**Planning Objection: CM/64/19/PL Langford, Horsemere Green Lane BN17 5QZ**

**Plot 8 deliberate misrepresentation by applicant to ADC**

Drawing Title:
HOUSE TYPE-F1
FLOOR PLANS

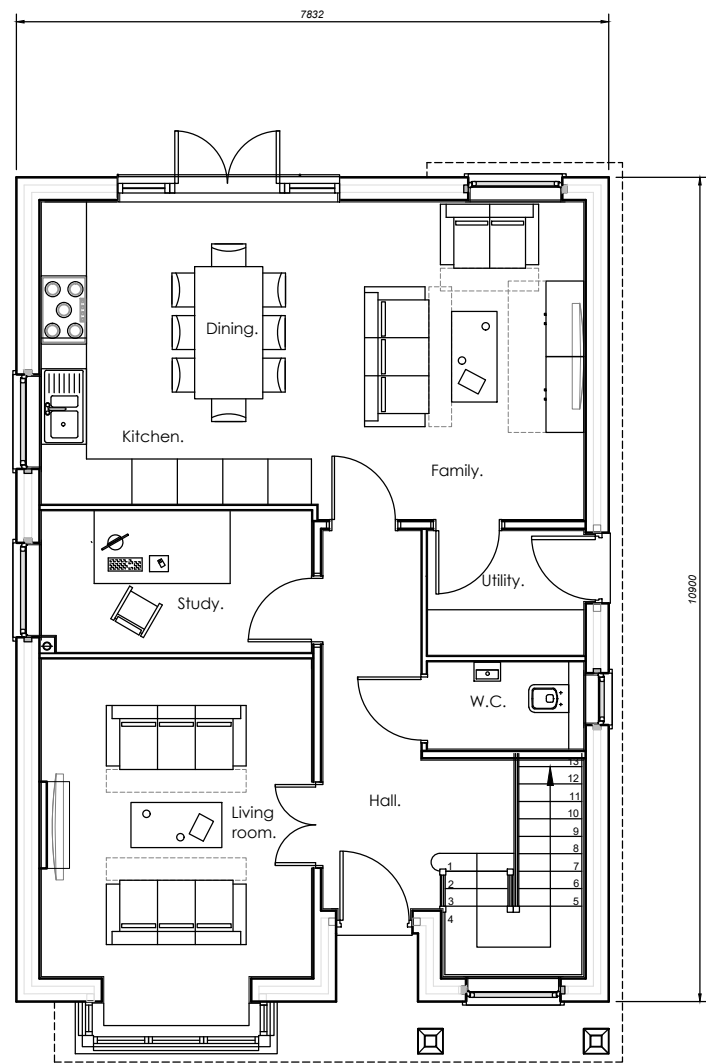
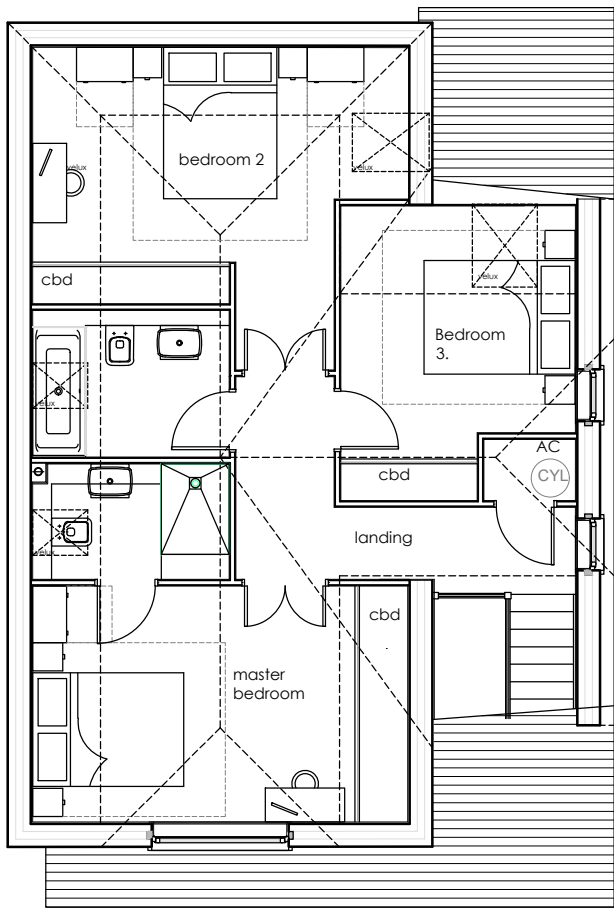
3. The value of my property has been badly affected.
4. PLOT 8 runs the length of my boundary. An application for a 4-bed house type E has been superseded by House type F described as a **3-bed BUNGALOW**. Having looked at the plans this is a **HOUSE** with 2 bedrooms and 2 bathrooms on the first floor, and one bedroom on ground floor. The whole length of the proposed house runs the whole length of my boundary, with permanent structure within feet of my fence. This is very intrusive, and will obliterate light for the majority of the day, completely unacceptable. I speak on behalf of myself and my affected neighbours.

6. If the applicant were to reduce the roof height to single storey, ie, that of a bungalow, as proposed, and lower the ground level, this would fall in line with their proposal of '**2 x 3-bed bungalows**' made to Arun District Council.
